RE: NARRABRI MINE MODIFICATION 5 – RESPONSES TO SUBMISSIONS

NCOPL's responses to the submissions received to date are presented in Attachment 1, with supporting information with respect to noise issued provided as Attachment 2 and a response to groundwater issues prepared by HydroSimulations provided as Attachment 3.

ATTACHMENT 1
RESPONSES TO SUBMISSIONS

Re: **Narrabri Mine - Longwall Panel
Width Modification – Groundwater
Modelling Assessment - Response
to DPI Water**

Figure 7.1 - Predicted subsidence impacts, Pine Creek and Pine Creek Trib. 3

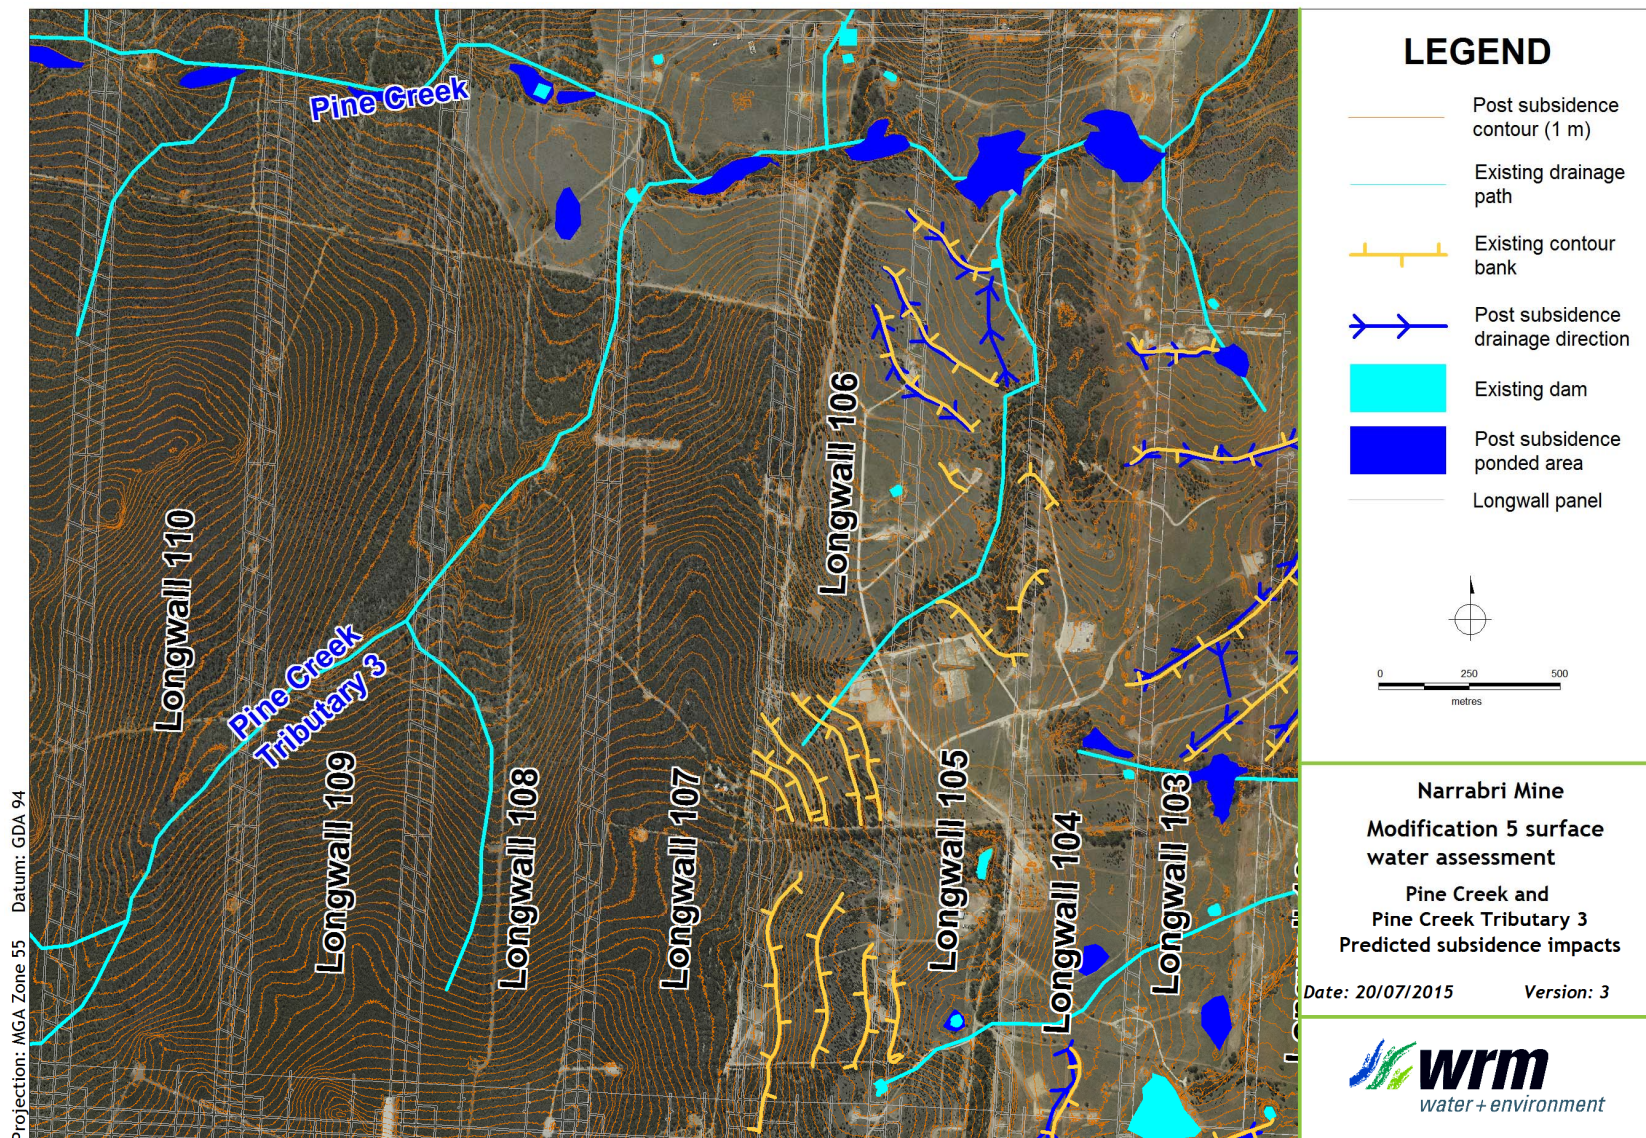
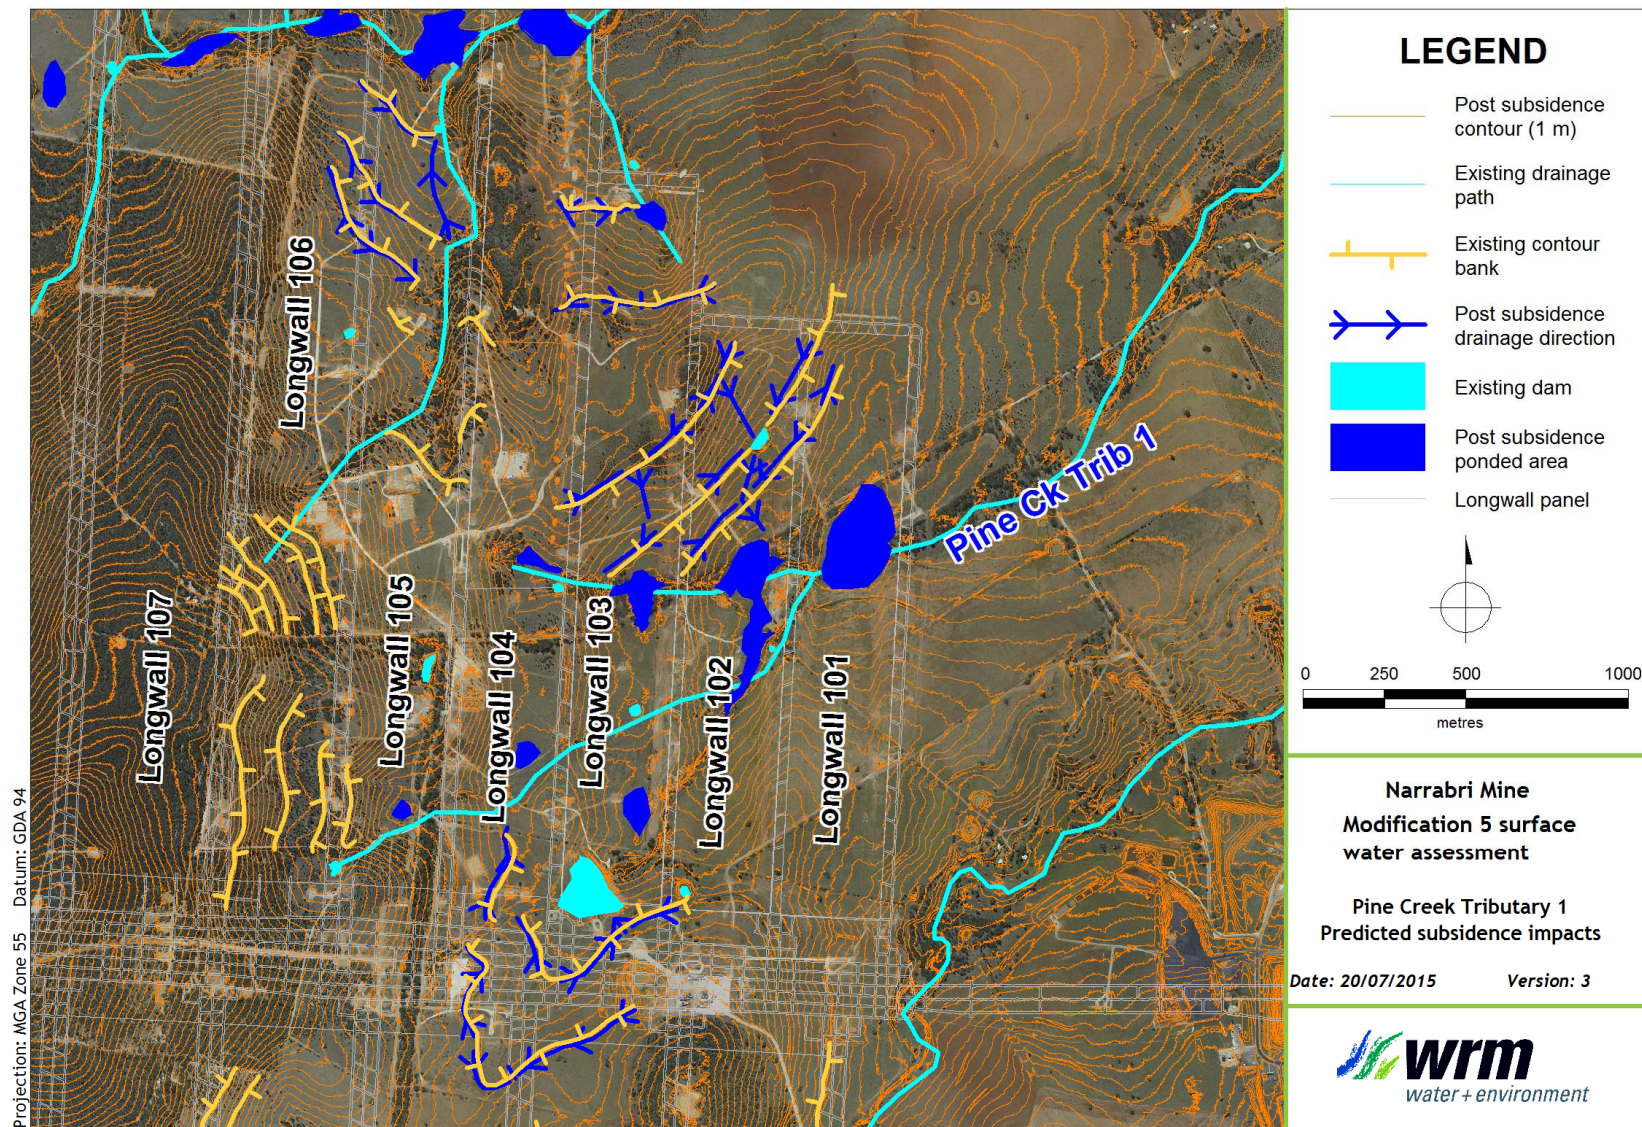
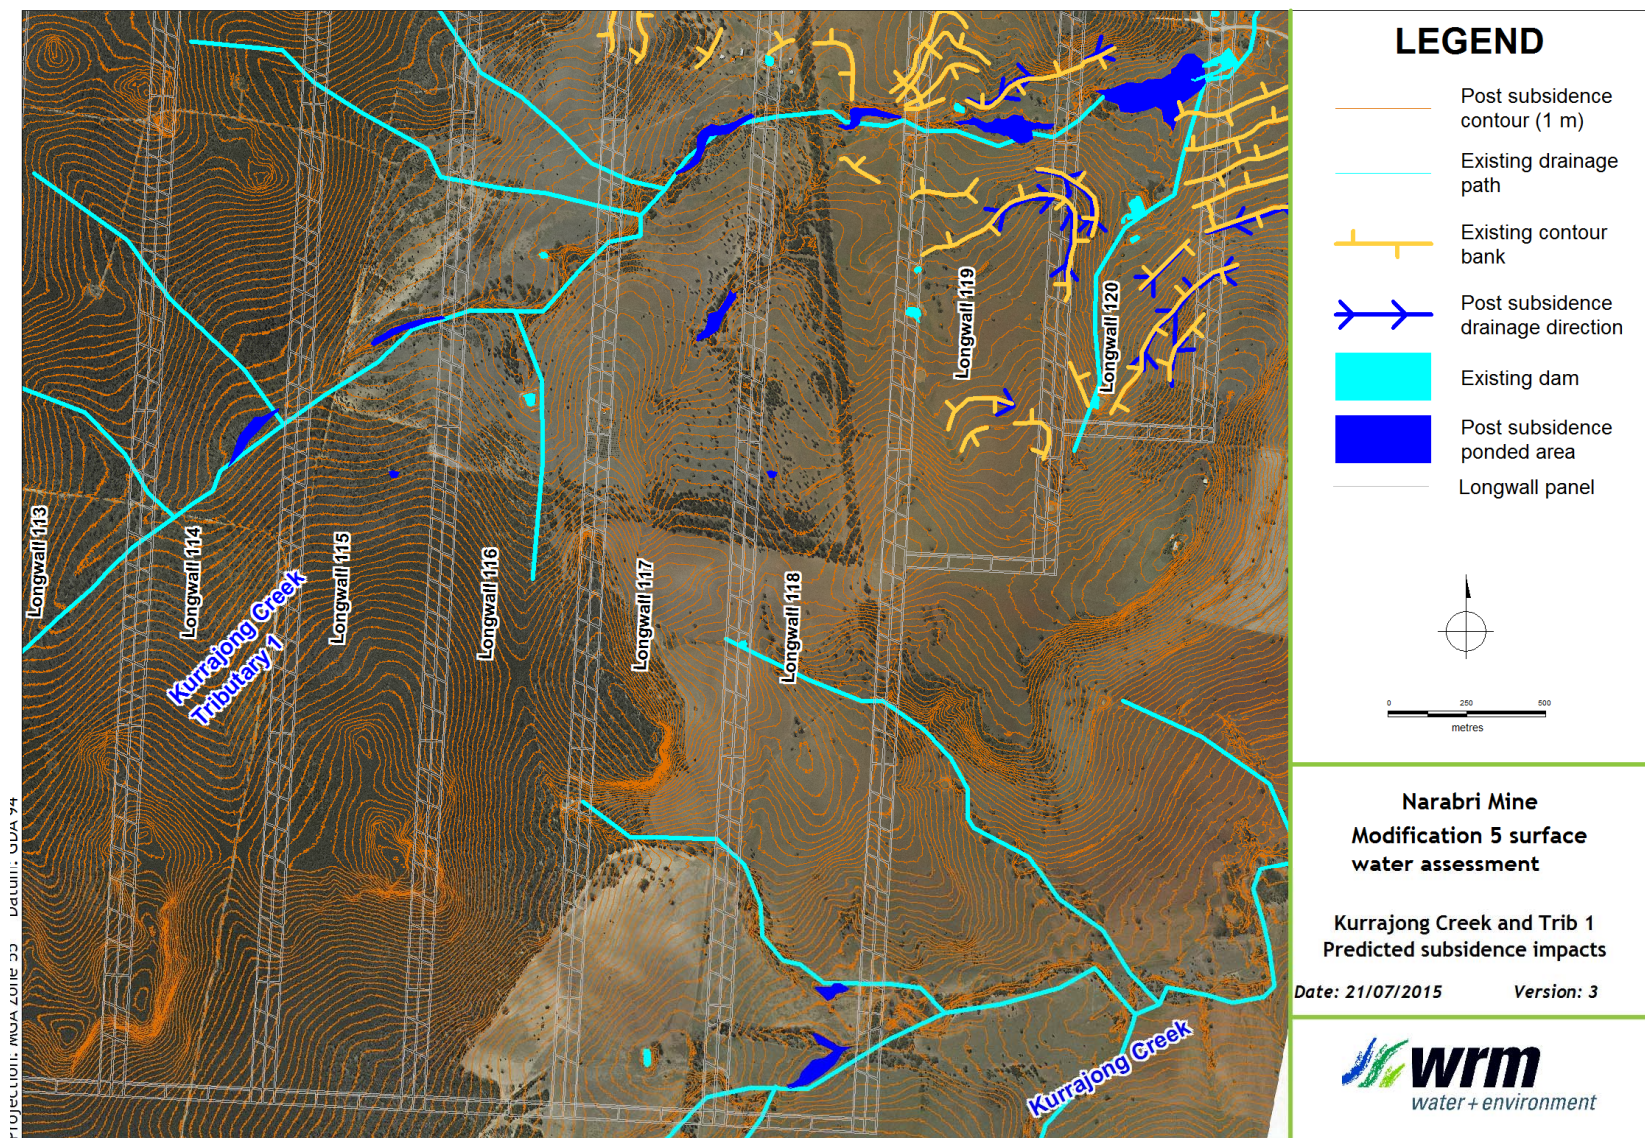
DPI-7	DPI-Water	Surface Water Assessment ... - The surface water assessment outlines a number of predicted subsidence impacts that could occur beneath Pine Creek, Pine Creek Trib. 1, Pine Creek Trib. 3, Kurralong Creek, Kurralong Creek Trib. 1 and Kurralong Trib. 2. These impacts include substantial in stream and over bank ponding, sedimentation of the channel in ponded areas, and some of the first order channels may drain into the major watercourses at alternate locations and cause localised bank scour. The surface water assessment outlines the impacts are generally consistent with the currently approved impacts however it is acknowledged the predicted impacts for the modification are moderately larger due to the more detailed LIDAR survey data available for this assessment. - The assessment outlines as a result of the modification there are going to be major impacts on the creeks, however the assessment concludes the geomorphic condition of the creeks won't be changed beyond the original assessment. It is unclear how the geomorphic condition of the creek will not be changed as a result of the major impacts predicted.	The Surface Water Assessment (WRM, 2015) does not describe that there would be "major" incremental subsidence impacts on creeks as a result of the Modification. WRM (2015) assessed the potential incremental subsidence impacts on creeks and concluded the following (Section 7.2 of the Surface Water Assessment): - Pine Creek and Pine Creek Tributary 3 – No additional impacts above the approved impacts given in WRM (2009) are expected. - Pine Creek Tributary 1 – These subsidence predictions and impacts are generally consistent with the approved impacts given in WRM (2009). - Kurralong Creek and Kurralong Creek Tributary 1 – The predicted impacts over the southern longwall panels are marginally greater than what has been predicted in WRM (2009) due to the improved ground level data. The differences are not significant and are expected to be minor. No subsidence impacts on Kurralong Creek Tributary 2 are expected as it is located outside of the underground mine footprint. Based on the above, WRM (2015) concluded the following in relation to potential incremental geomorphological impacts (Section 7.2.5 of the Surface Water Assessment): Overall the impacts are generally consistent with the currently approved impacts described in WRM (2009). ... An inspection of the results suggests that major changes in channel

Number	Individual/ Organisation	Submission	NCOPL Response
			<i>morphology are not expected. Significant changes in channel location (avulsions) are unlikely across the mine subsidence zone. However, some of the minor (first order) channels may drain into the major watercourses at alternate locations and cause localised bank scour. Some sedimentation of the channel is expected in the ponded areas, which may change the channel form over time. Again, these impacts are in accordance with the approved impacts given in WRM (2009).</i> The more detailed LIDAR survey data available for the WRM (2015) assessment compared the WRM (2009) assessment has allowed for more detailed assessment of potential geomorphological impacts. In some instances, this has resulted in the predicted modified impacts being greater than described in WRM (2009) despite there being little of no change to the predicted subsidence levels.
